Harnett County Government Complex
307 Cornelius Harnett Boulevard
Lillington, NC 27546

October 27, 2006

Re: Status of Improvement Permit Application #06-5-15616

H0H Const.  
Lot 150 Woodshire  
06-500 15616

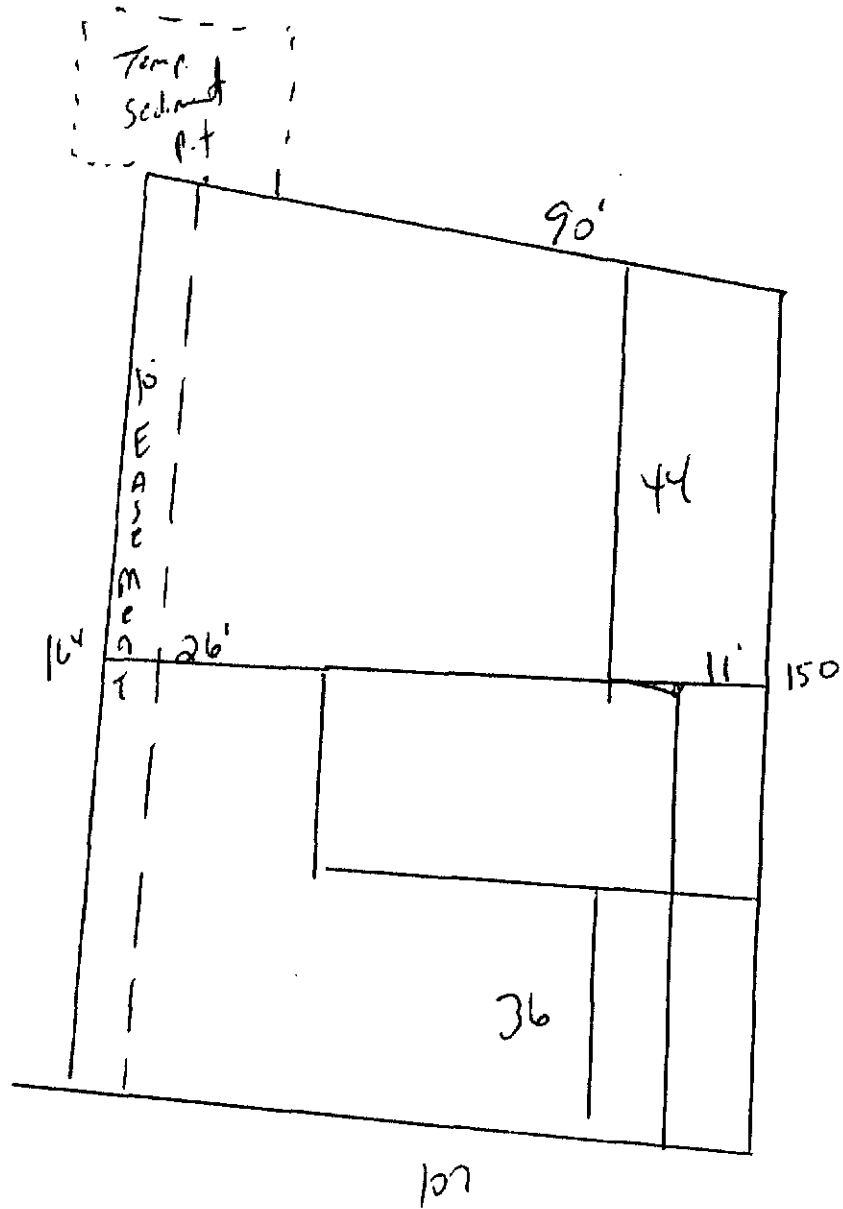
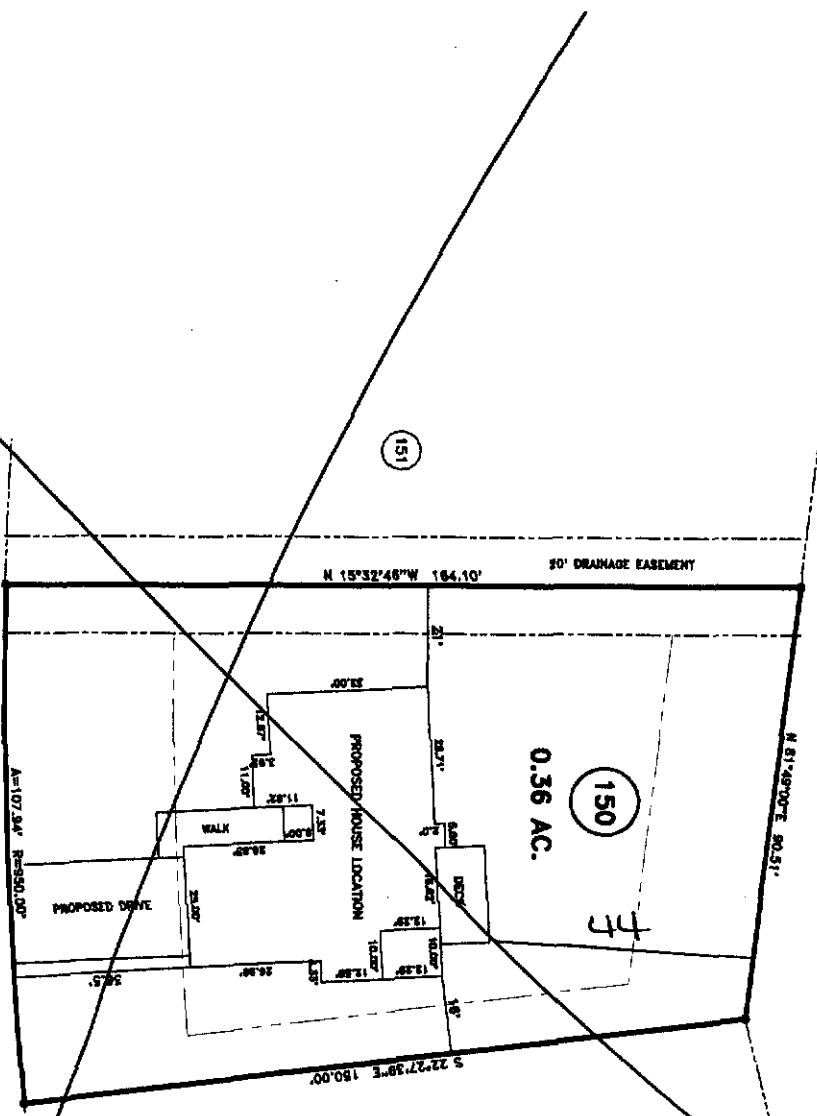
- 1. Property lines/corners not marked or labeled
- 2. House corners not marked or labeled
- 3. Directions not clear to property
- 4. Property needs brush or vegetation removed
- 5. Backhoe pits required
- 6. Other – **Move house as shown on attached sheet and resubmit to Central Permitting.**
